WEST SUSSEX COUNTY COUNCIL CONSULTATION

TO:	Arun District Council FAO: Amy Myer
FROM:	WSCC - Highways Authority
DATE:	25 October 2021
LOCATION:	22 Vermont Drive, East Preston, BN16 1LA
SUBJECT:	EP/125/21/PL Demolition of existing single storey projection on host dwelling, removal of swimming pool and erection of 1 No. detached 1 1/2 storey self-build dwelling with detached garage building on existing garden land. This application is in CIL Zone 4 and is CIL liable as new dwelling.
DATE OF SITE VISIT:	N/A
RECOMMENDATION:	Advice
S106 CONTRIBUTION TOTAL:	N/A

Detached Garage - Plans &
Elevations

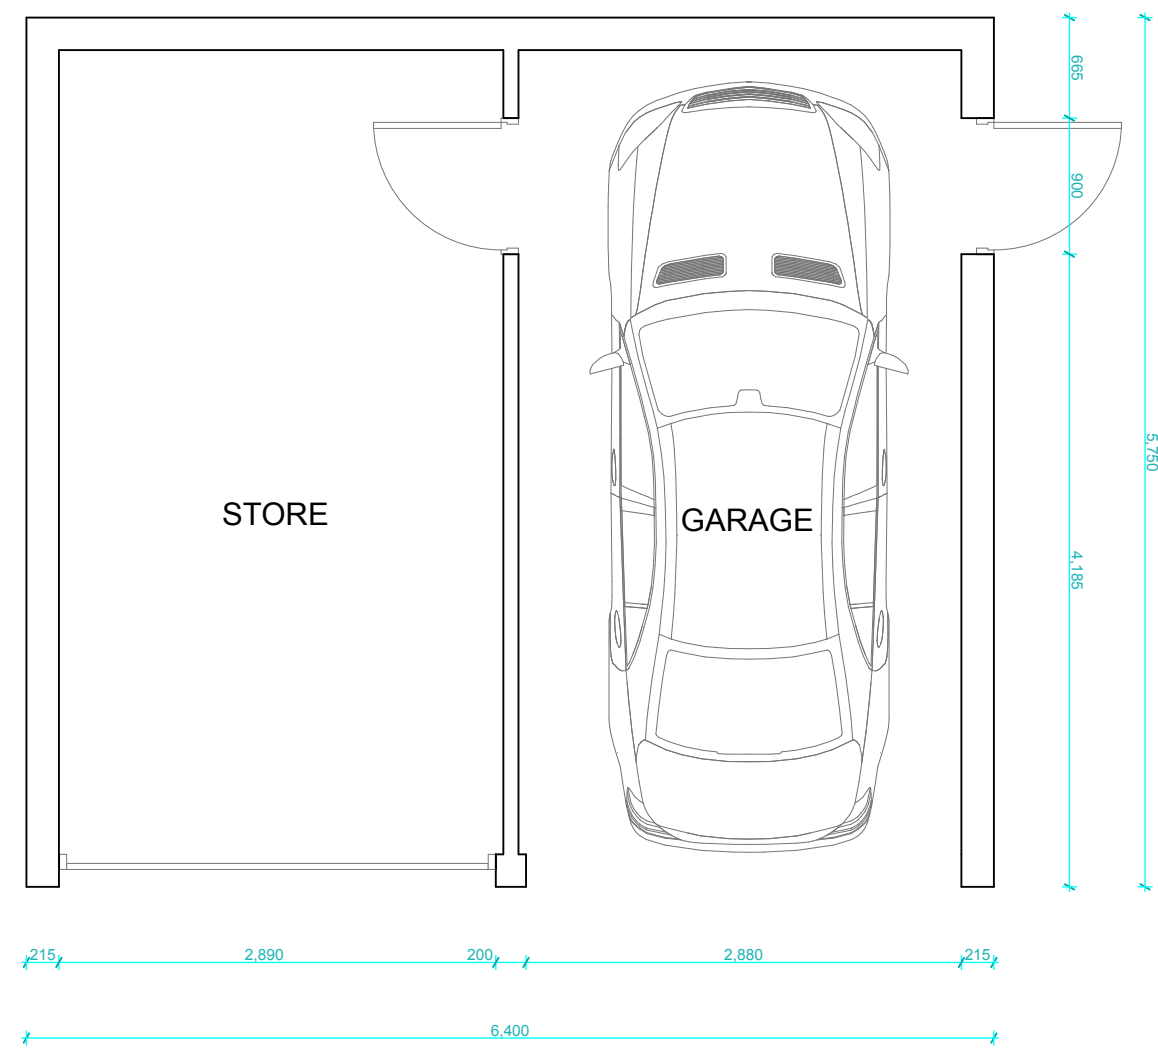
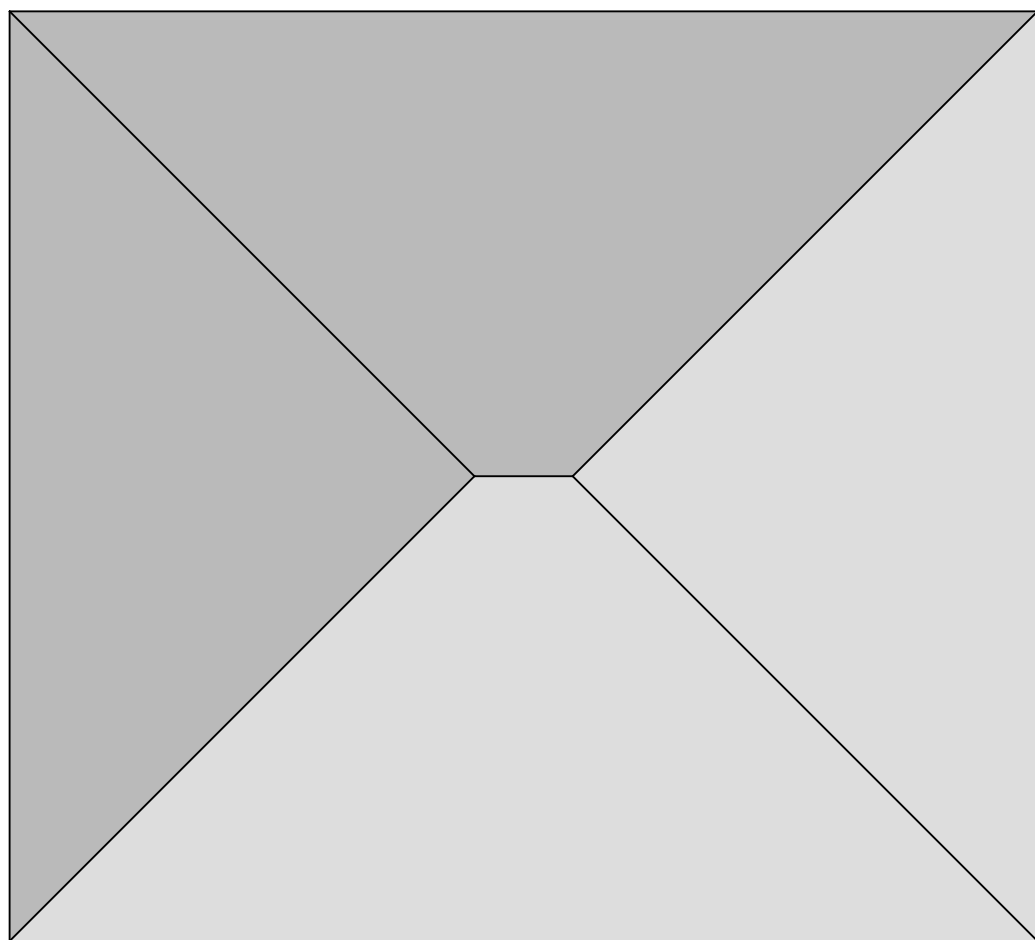
However, the LHA notes that the proposed garage falls short of the minimum internal dimension requirements of 3m x 6m, as set out in Manual for Streets (MfS), to be considered for parking provision. The garage as proposed has approximate internal dimensions of 2.9m x 5.3m, which may be too small for modern cars to be accommodated within. Therefore, the LHA advises the applicant to enlarge the proposed garage, so that it can be considered for vehicular parking provision.
